Colorado Springs, CO

Final Report - Corrections Required **Application No. LUPL-25-0008**

Document Filename : 241010_BLR Village C Land Use Plan.pdf

BANNING LEWIS RANCH - VILLAGE C

1

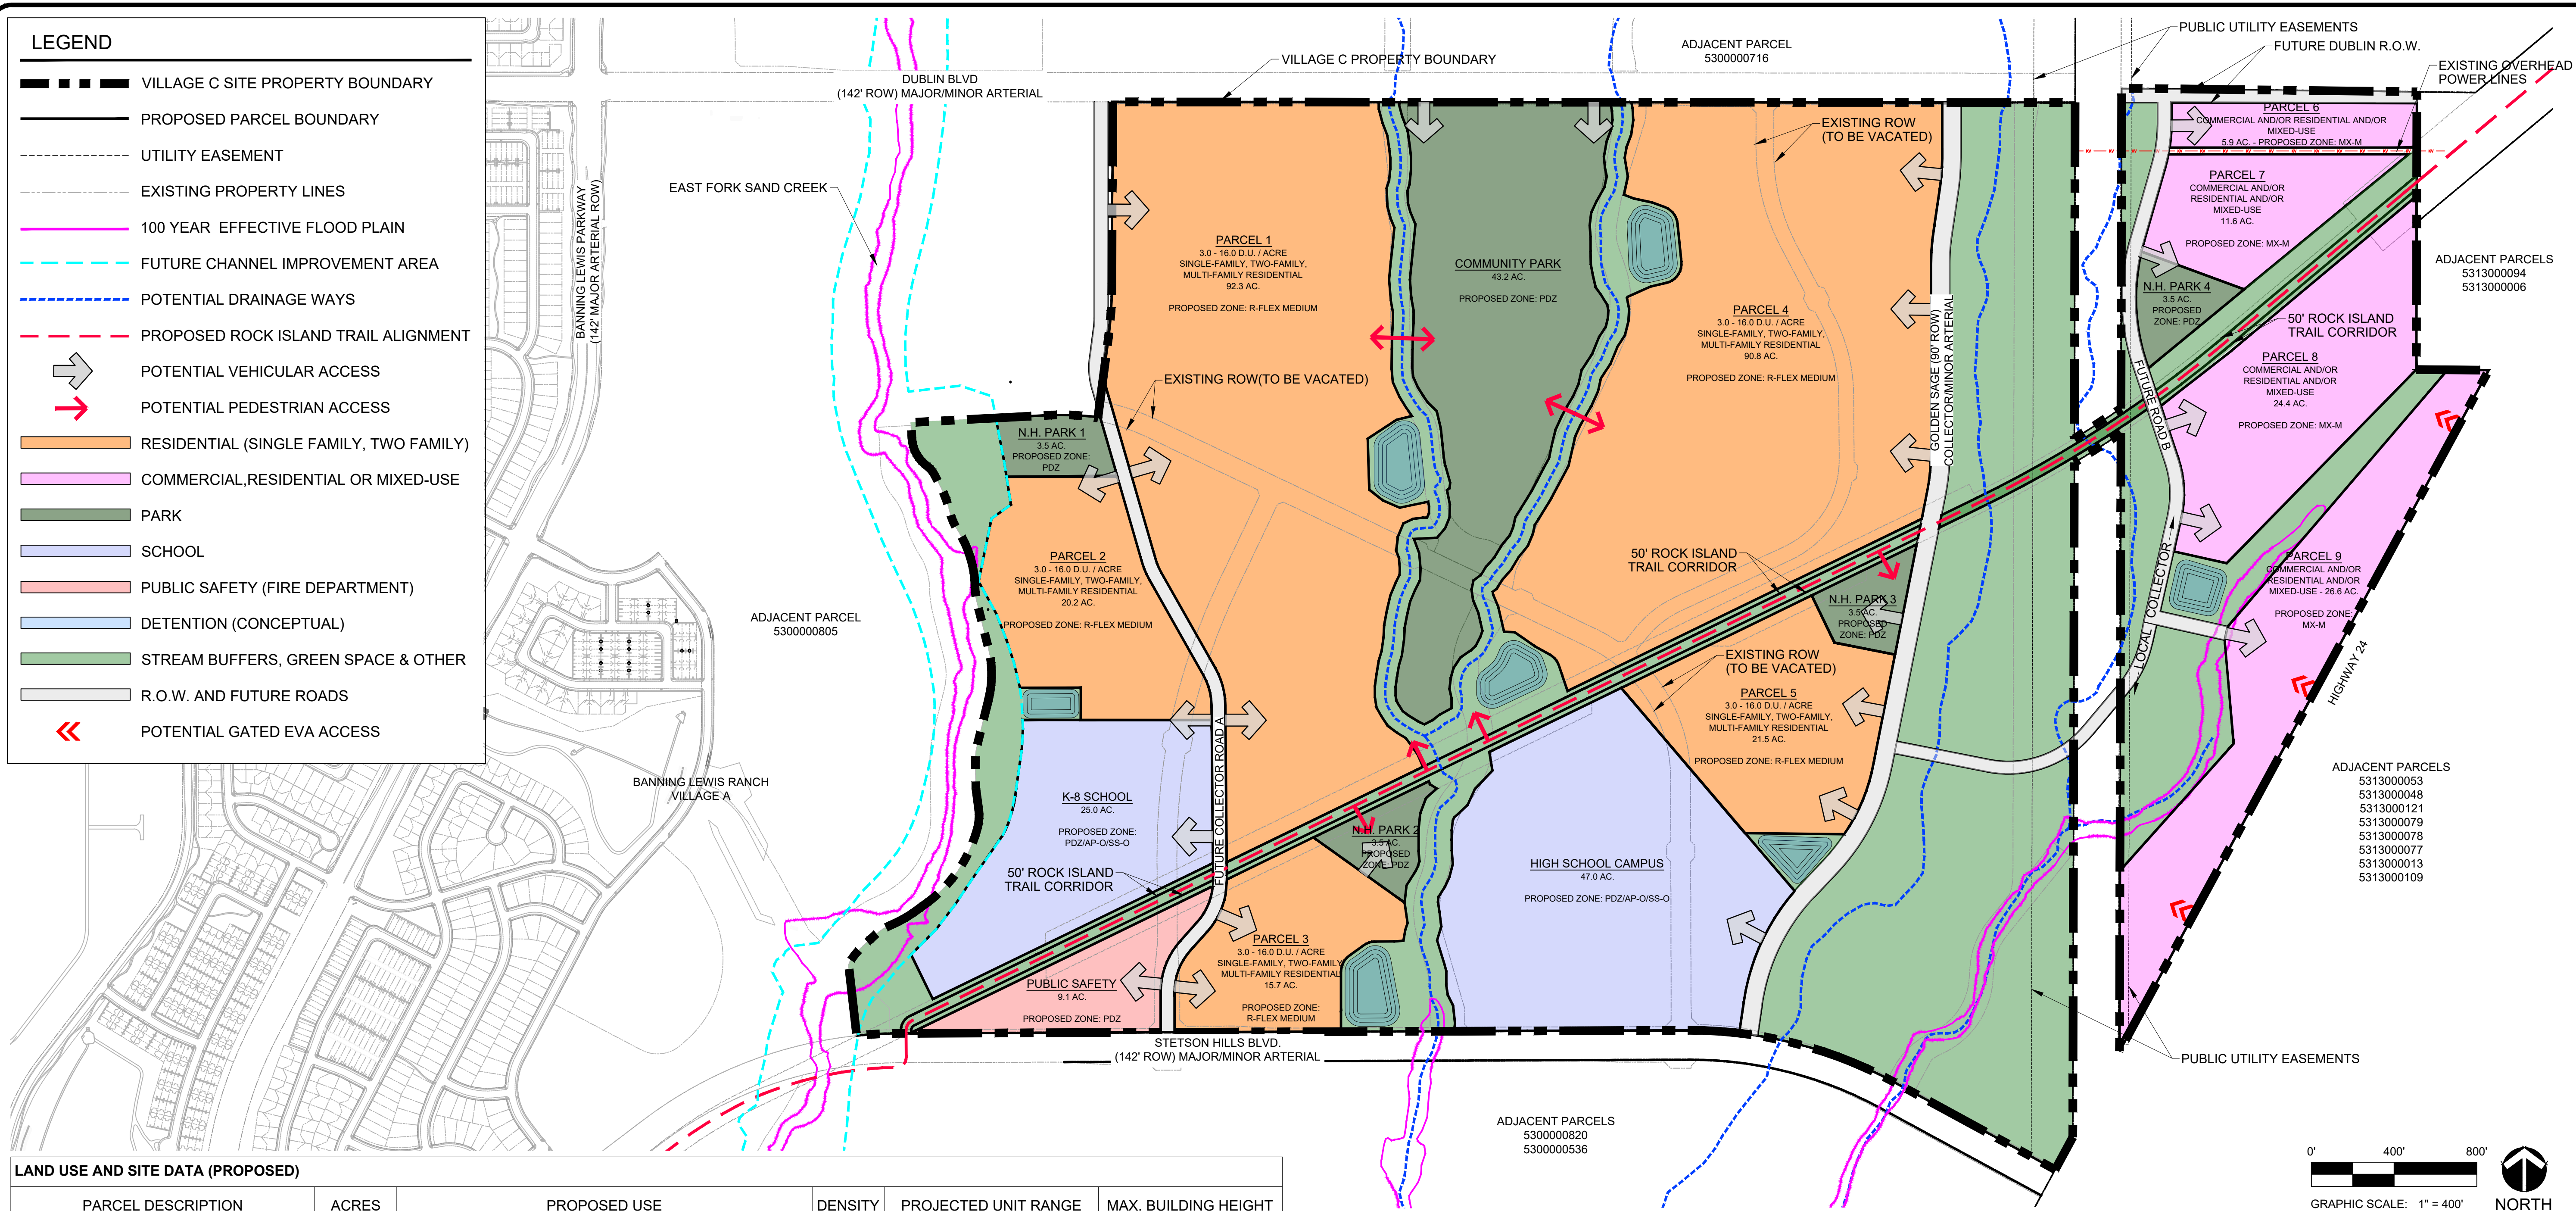
Comment ID	Page Reference	Reviewer : Department	Review Comments
9	1	Erica Schmitz : City Engineering - SWENT	The existing channel must be shown and labeled and if the existing channel is not stabilized, it may be required to be stabilized. Please reach out to the Lead Reviewer to set-up a meeting to discuss the channel improvements and to schedule a site visit.
10	1	Erica Schmitz : City Engineering - SWENT	Add a note calling out channel improvement requirements associated with the Site, including responsible party, long-term maintenance responsibility, and timing requirements. If not applicable, provide a note stating channel improvements are not required.
11	1	Erica Schmitz : City Engineering - SWENT	Info Only: Please contact the Lead Reviewer, Erica Schmitz (erica.schmitz@coloradosprings.gov) with any questions related to SWENT comments. Please reference the Planning review number in all communications.

Comment ID	Page Reference	Reviewer : Department	Review Comments
6	1	Joel Dagnillo : City Engineering Dev Review	Please add the following note to Cover Sheet: "This property is subject to the findings, summary and conclusions of a geologic hazard report prepared by Entech Engineering, Inc. dated May 1, 2020 (revised June 17, 2020), which identified the following specific geologic hazards on the property: areas of hydrocompaction, loose soils, potentially expansive soils, erosion, seasonal and potentially seasonal shallow groundwater areas, ponded water, floodplains and artificial fill. A copy of said report has been placed withing the subdivision file of the City of Colorado Springs Planning and Development Team. Contact the Planning and Development Team, 30 South Nevada Ave, Suite 701, Colorado Springs, CO, if you would like to review said report."
7	1	Joel Dagnillo : City Engineering Dev Review	Add a note stating the timeline in which Dublin and Stetson Hills will be constructed and by whom.

13	1	Joel Dagnillo : City Engineering Dev Review	All public improvements to be built to City Standards, and specifically called out as so on forthcoming Development Plan(s). Construction plans and financial assurances will also be required as this project progresses.
8	2	Joel Dagnillo : City Engineering Dev Review	All accesses and required public improvements along Highway 24 will have to be coordinated with CDOT.
1	1	Matthew Alcuran : Col Springs Utilities	**Springs Utilities comment to applicant: Springs Utilities comments will be provided at the time of the required Preliminary Utility and Public Facilities Plan submittal associated with the development plan entitlement.
14	2	Steve Smith : Fire	For response purposes, the fire station/public facility location, is better suited in this corner.
3	1	Allison Stocker : Planning	Informational reminder to staff: Prior application is under PDZL-24-0005

15	1	Caroline Miller : Planning	PLDO Reviewer would like for Village B2 and C to go to Parks Advisory Board prior to City Planning Commission to highlight PLDO obligations through the Master Plan/Land Use Plan and how they are to be met through the spread of Neighborhood Parks and summed Village C Community Park site. This will take two months, the first month as a presentation item, the second month as an action item, once Parks comments are resolved on Village C. In addition, Parks is awaiting feedback regarding the developer building the Community Park, then dedicating it to the city. A Community Park amenity list was provided in April to help the conceptual feasibility discussions. Notes will likely be added to this LUP in the future, upon developer response.
31	1	Caroline Miller : Planning	Please add a note that Rock Island Trail easements will be provided at time of adjacent development.

37	1	Tamara Baxter : Planning	I would reference the Development Standards Adjustments as well, as this will be applicable for future DPs.
39	1	Tamara Baxter : Planning	Change to "SS-O" per UDC. Correct through out plan set.
40	1	Tamara Baxter : Planning	Please look at the definition of dwelling specific to two family attached and two-family (duplex) attached. Please clarify if one or the other or both are intended.
48	1	Tamara Baxter : Planning	What is intended as 'mixed-use'?
51	1	Tamara Baxter : Planning	This comment is also applicable to the Development Standards Adjustment application(s). Please refer to UDC Section 7.4.201.C [Table 7.4.2-C] Notes 1 and 3.
56	1	Tamara Baxter : Planning	Identify which version. Thank you for including.
57	1	Tamara Baxter : Planning	Plannign staff reverses the right to provide additional comments with a resubmittal.
